Rezoning Transportation Analysis

Petition Number: #2021-256

Date	Description
04-12-2022	First Review (AO)
08-22-2022	Second Review (AO)
01-25-2023	Third Review (TM)
03-22-2023	Fourth Review (DR)

**TECHNICAL PLAN
SHEET**

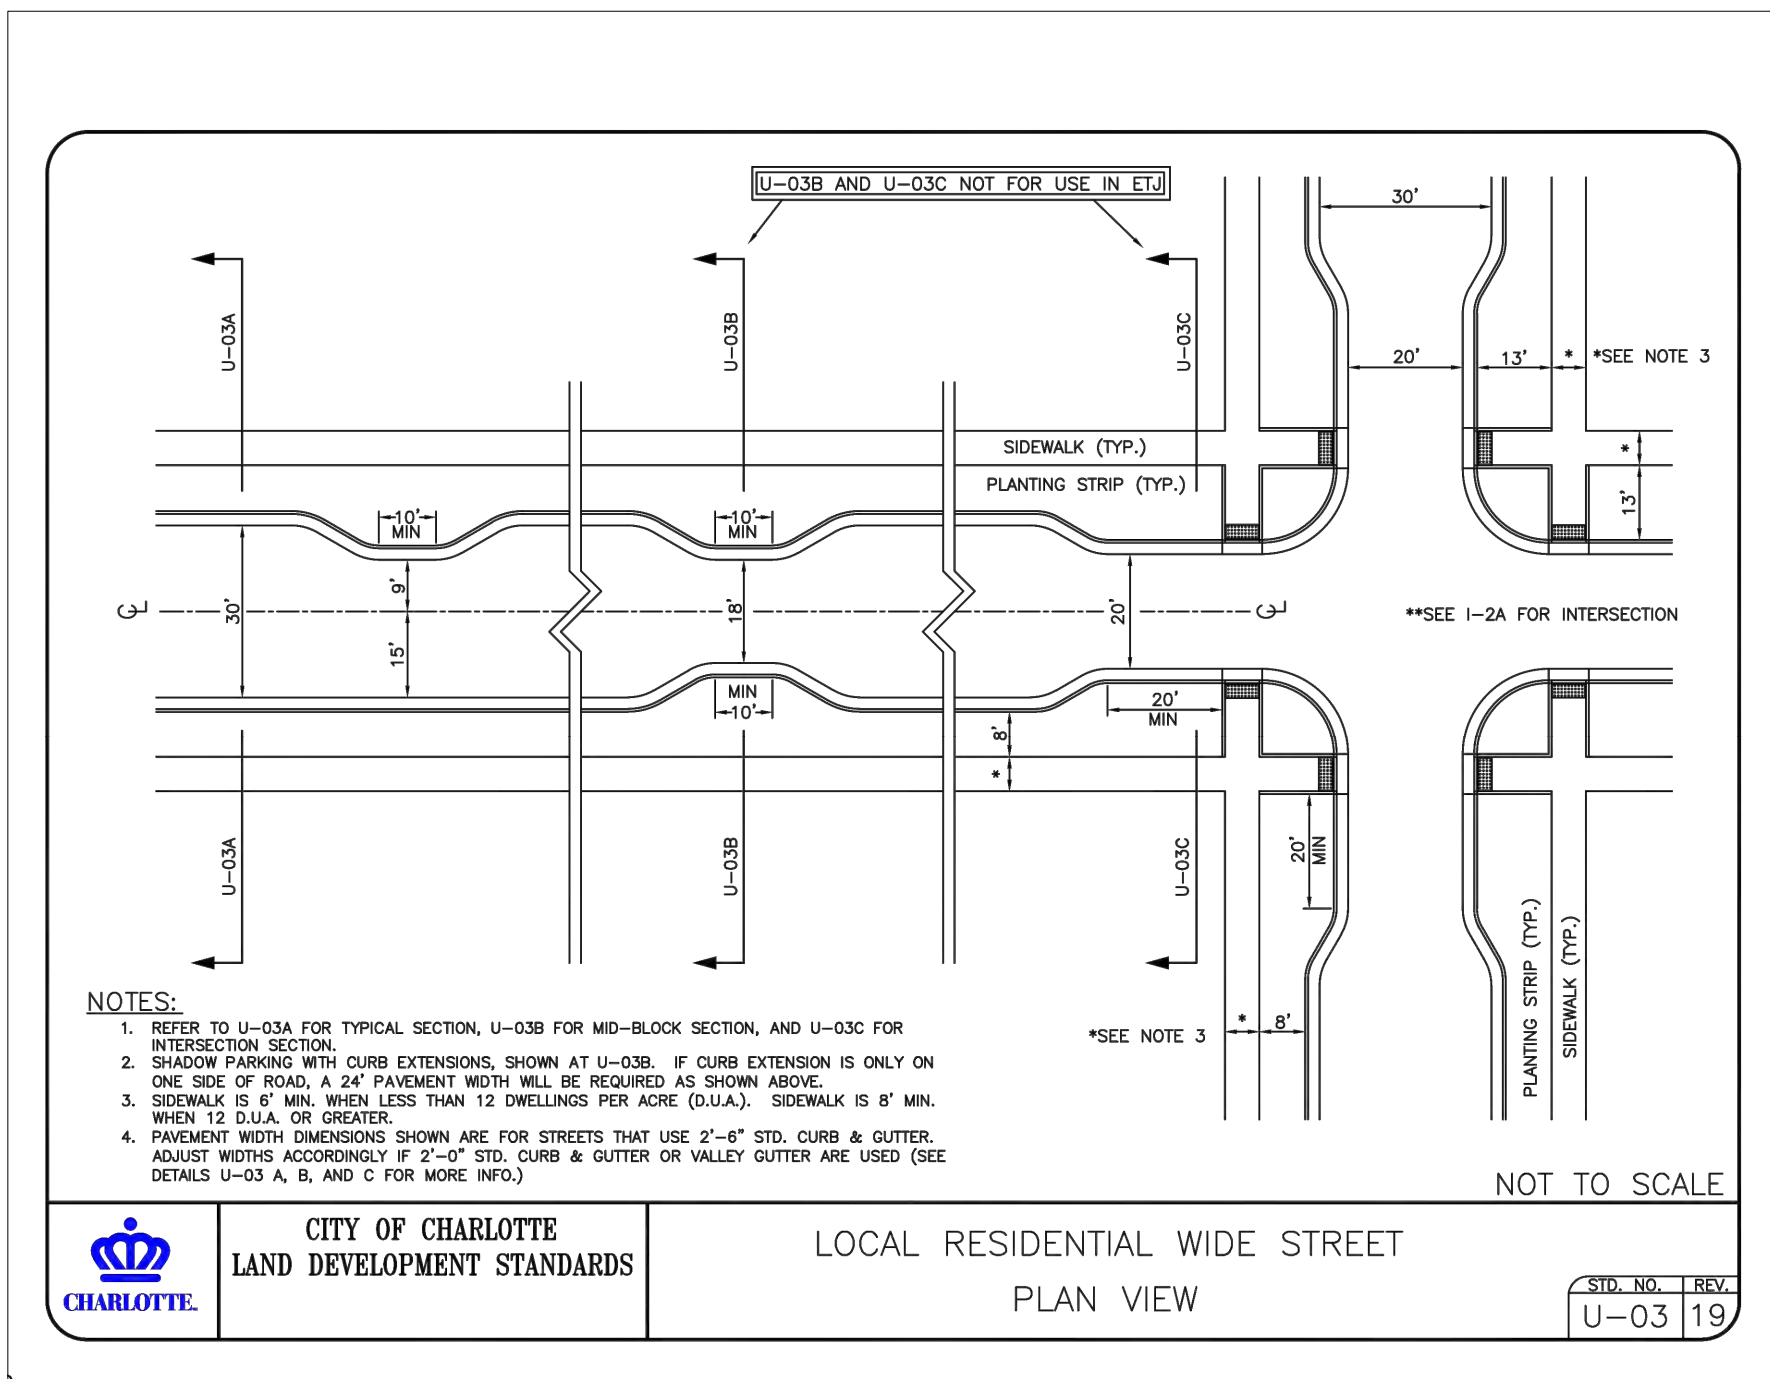
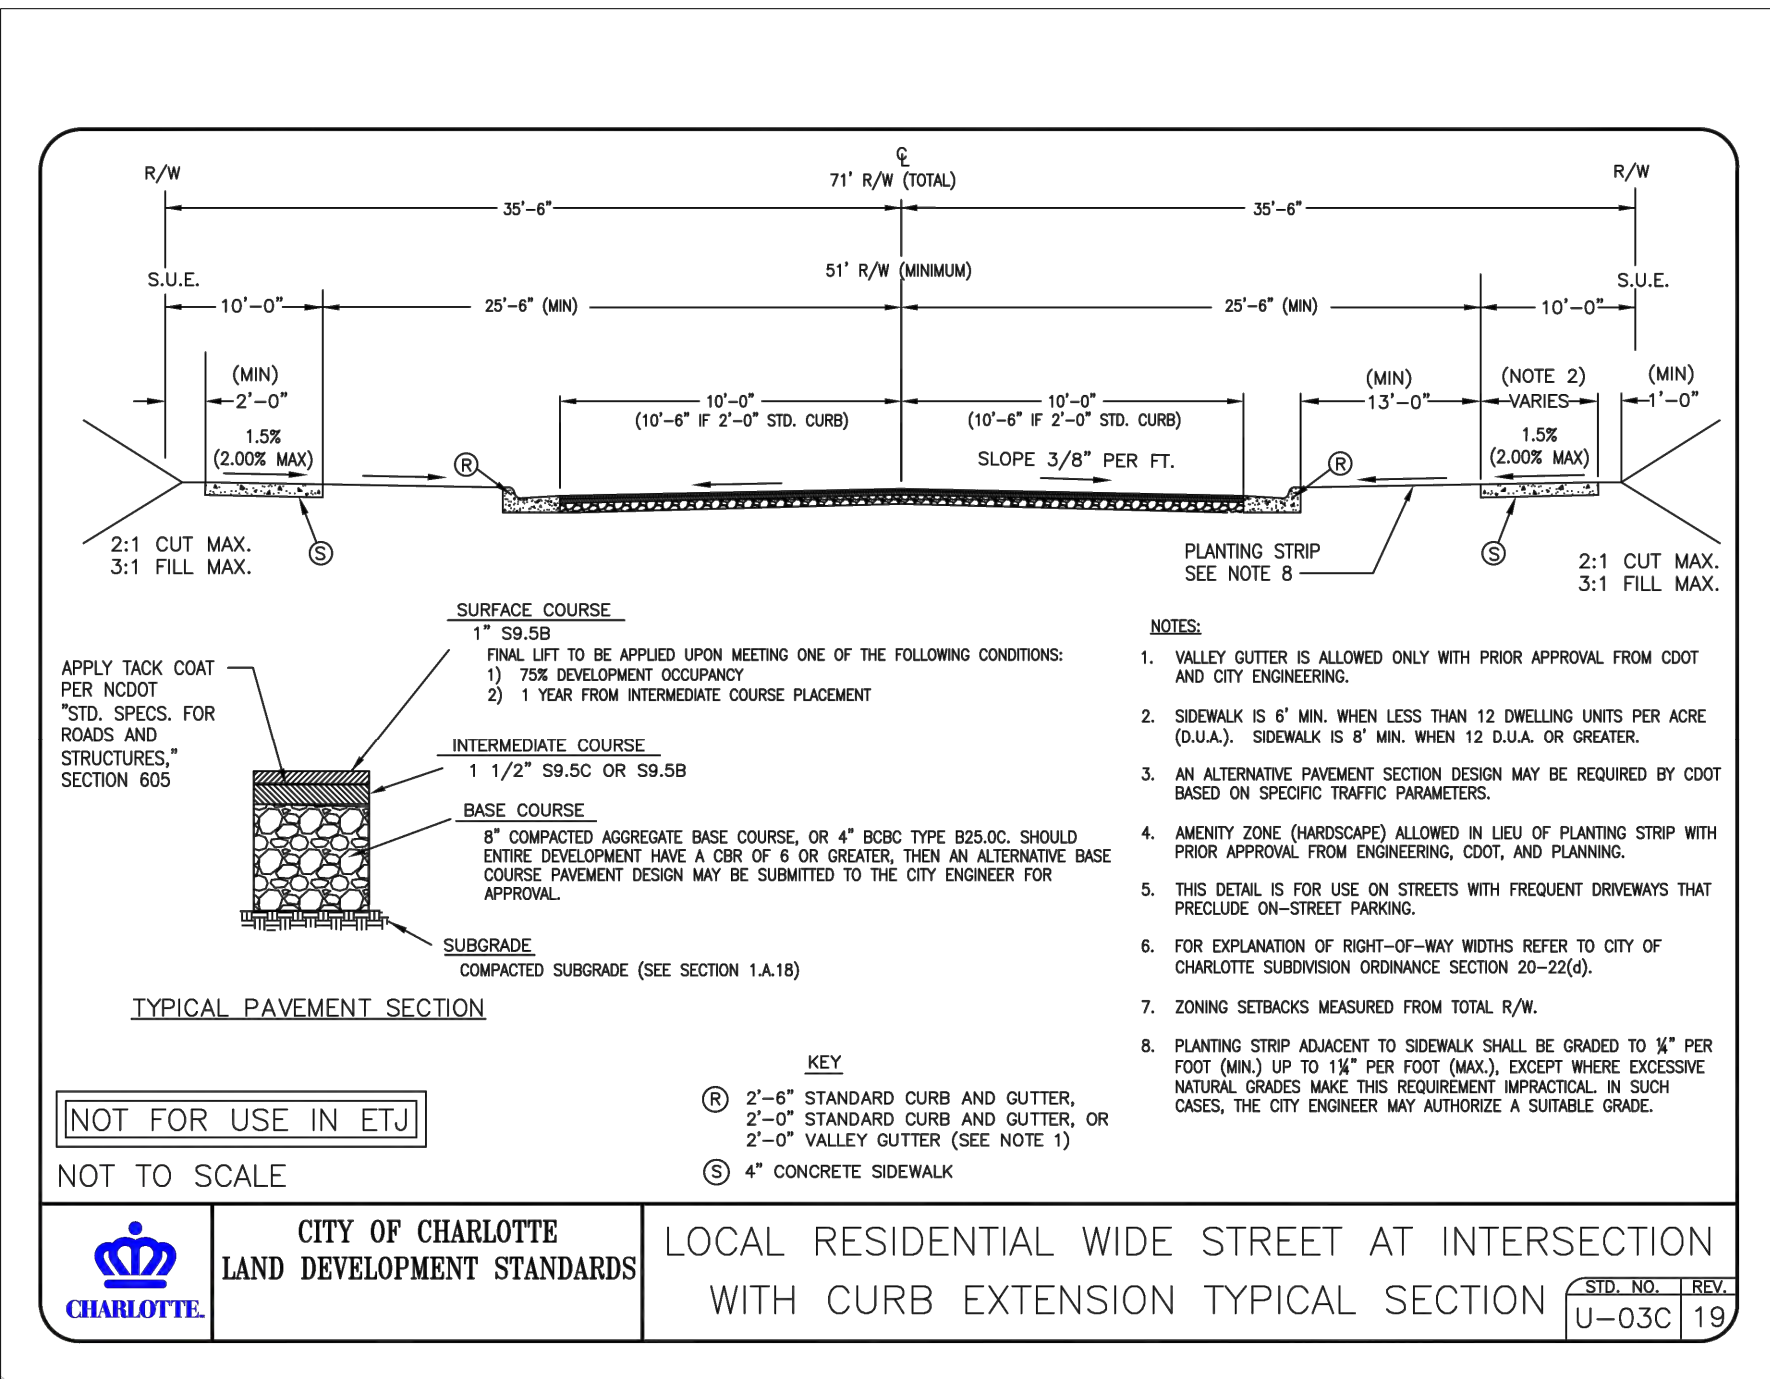
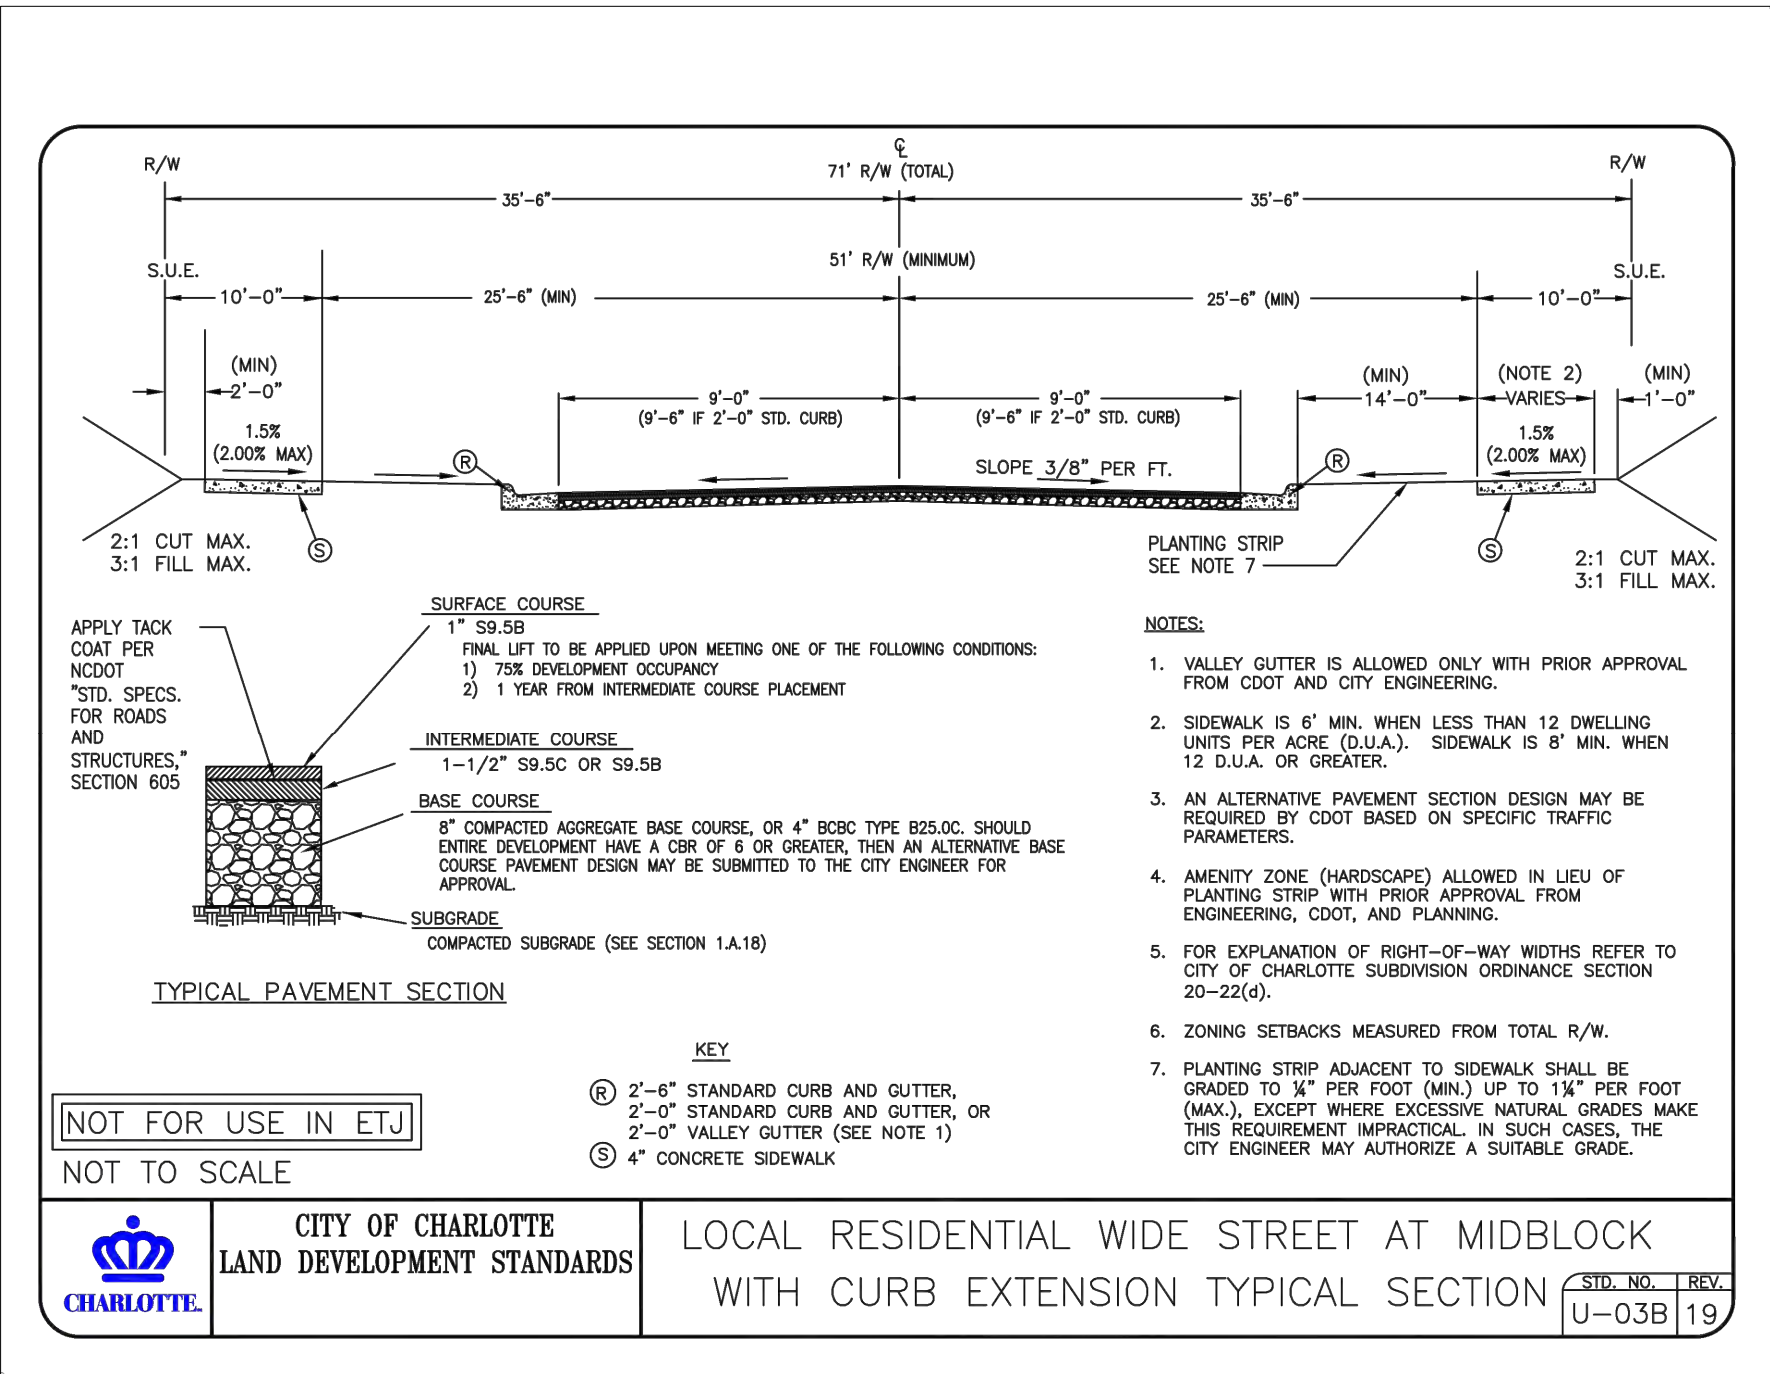
Clarifying Comment 3-22-23: Update conditional transportation notes to include the required transportation improvements from the approved TIS.
